# THE SOD GUY - SALES LOT

SITE DEVELOPMENT PLANS  
LOT 1, APPALOOSA HIGHWAY 24 SUBDIVISION

**SALES LOT - SPECIAL USE**  
**LIGHTING PLAN**

SHEET NO:  
**LP-01**  
DATE:  
12/30/18  
PAGE NO:  
1 OF 1

P:\Clients\The Sod Guy\CAD\Development Plan\Lighting Plan.dwg ----- 9/12/2019 9:41 AM

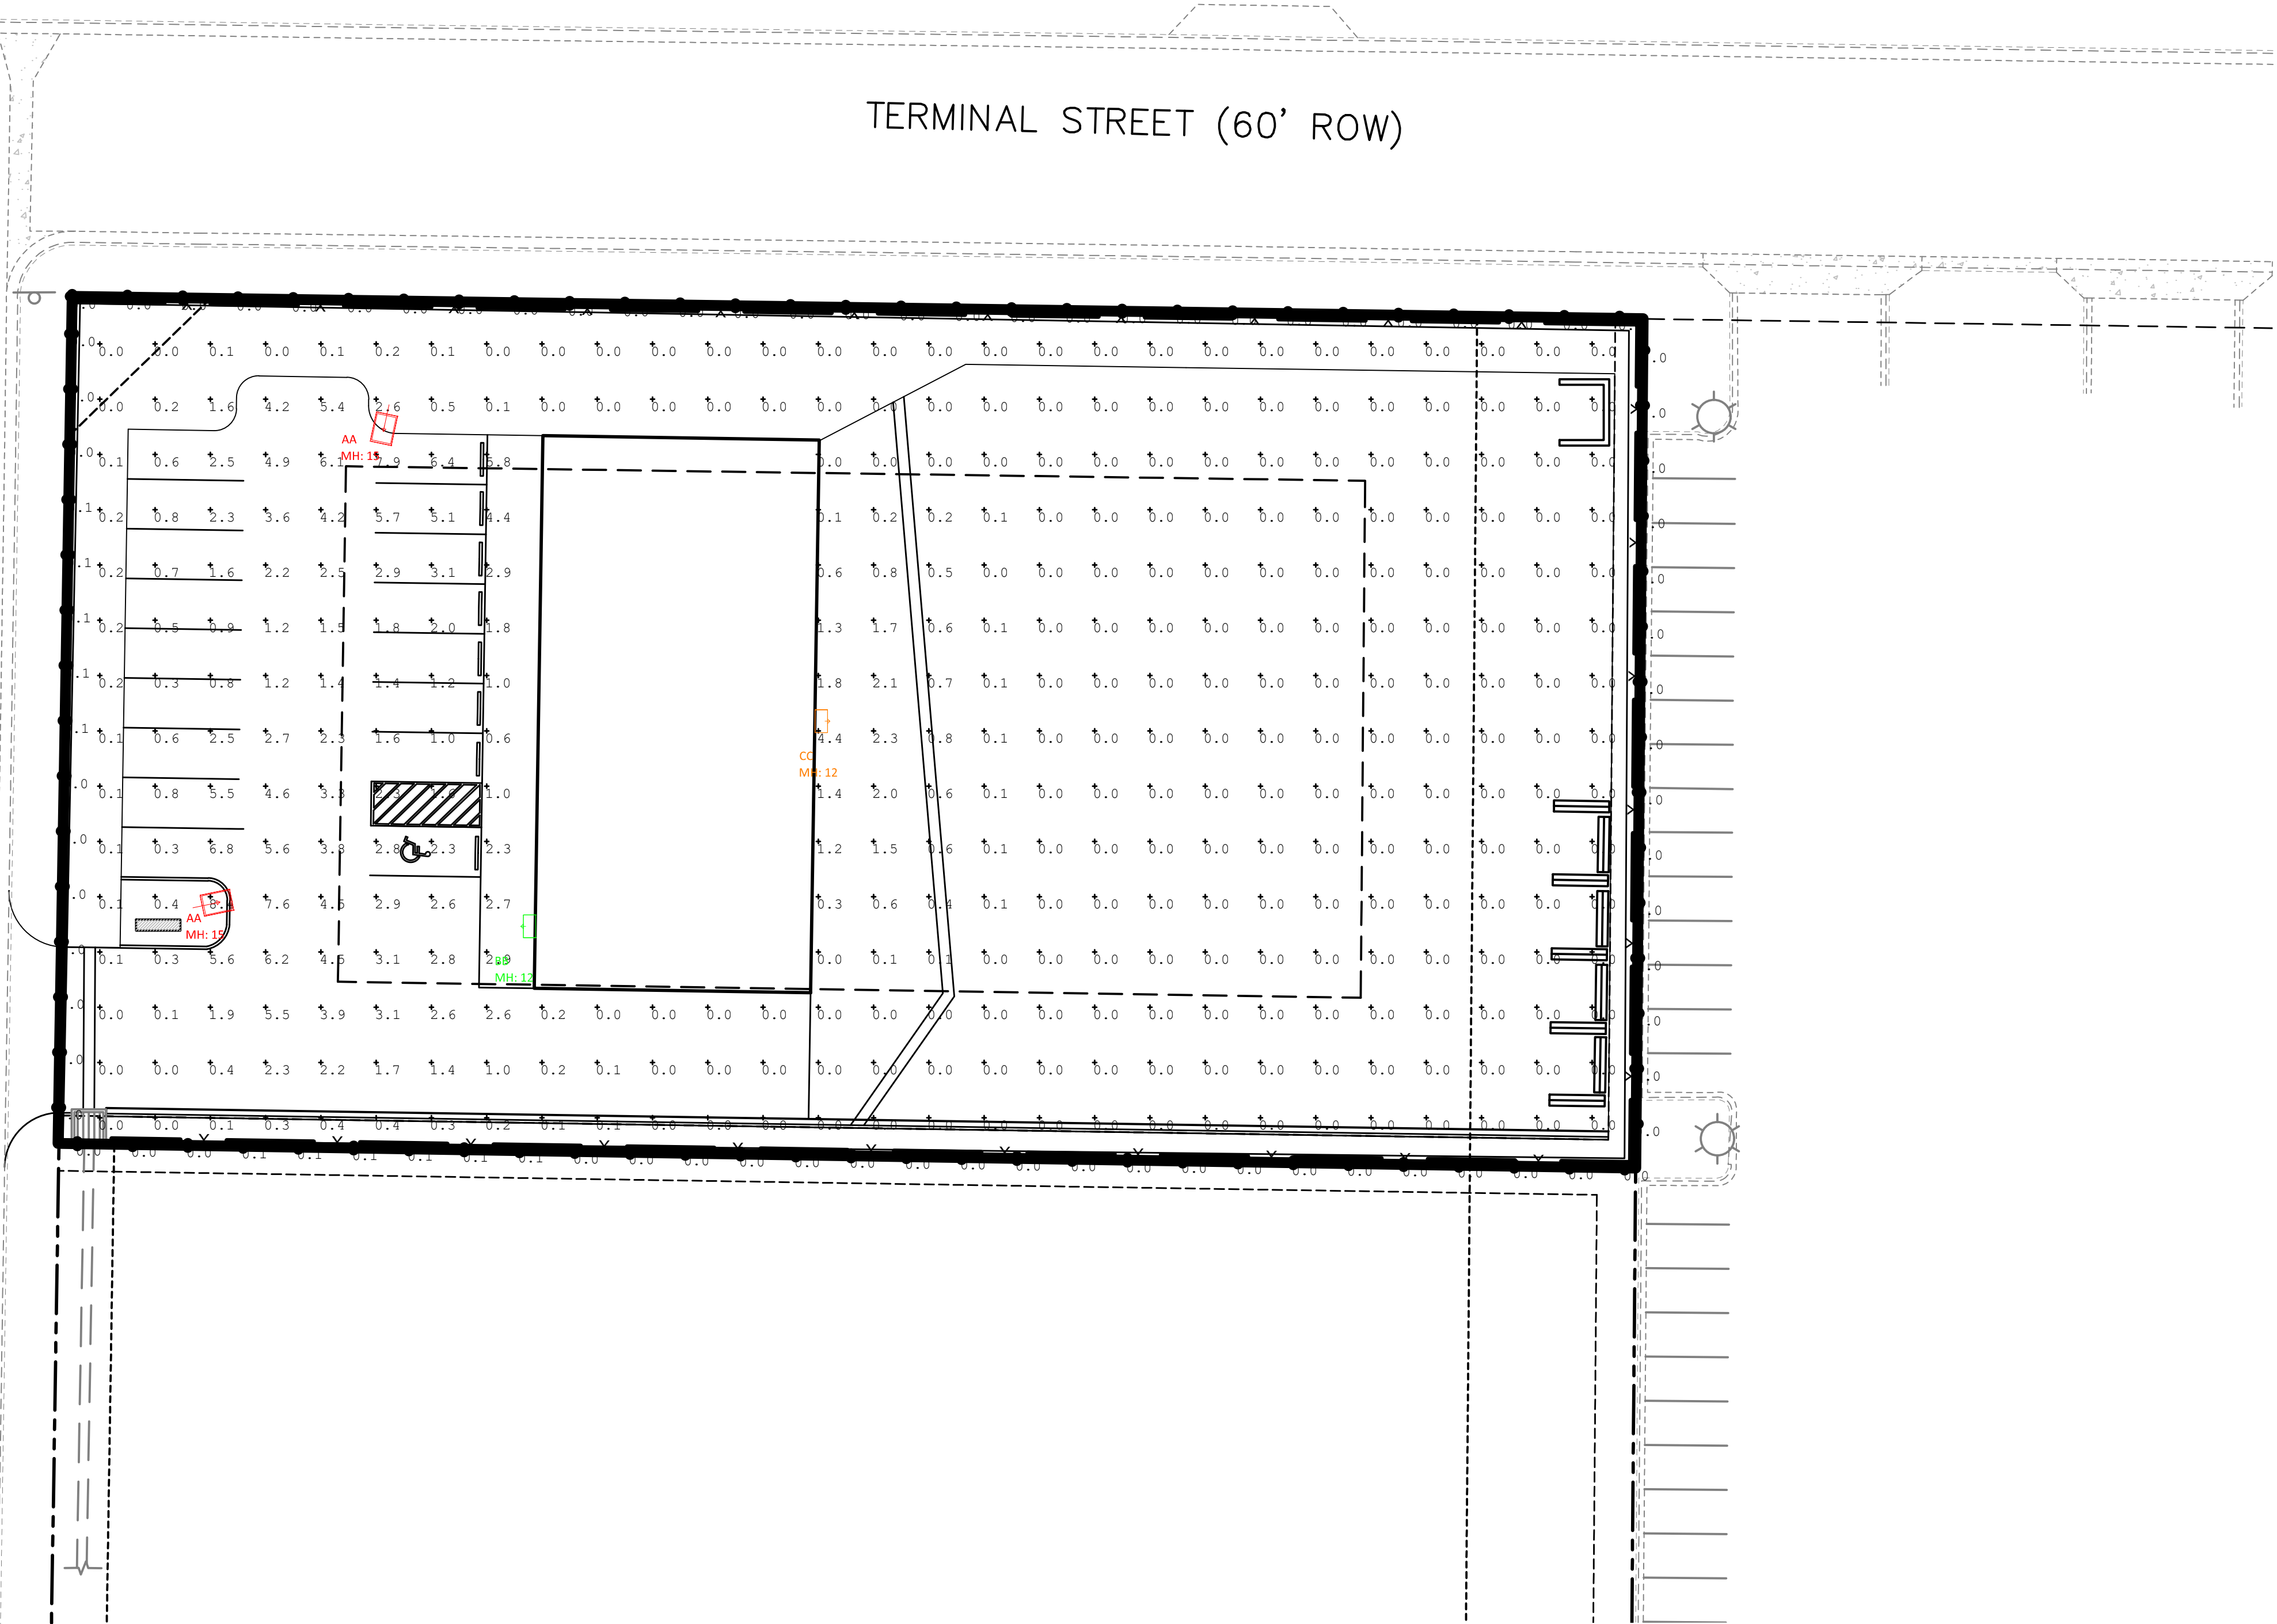
Maximum at property boundary is 0.1 fc. when adjacent to public right-of-way.

Maximum levels are 10 fc unless at loading and unloading docks.

Show height of light poles as well as details showing that they are concealed or shielded.

Too bright
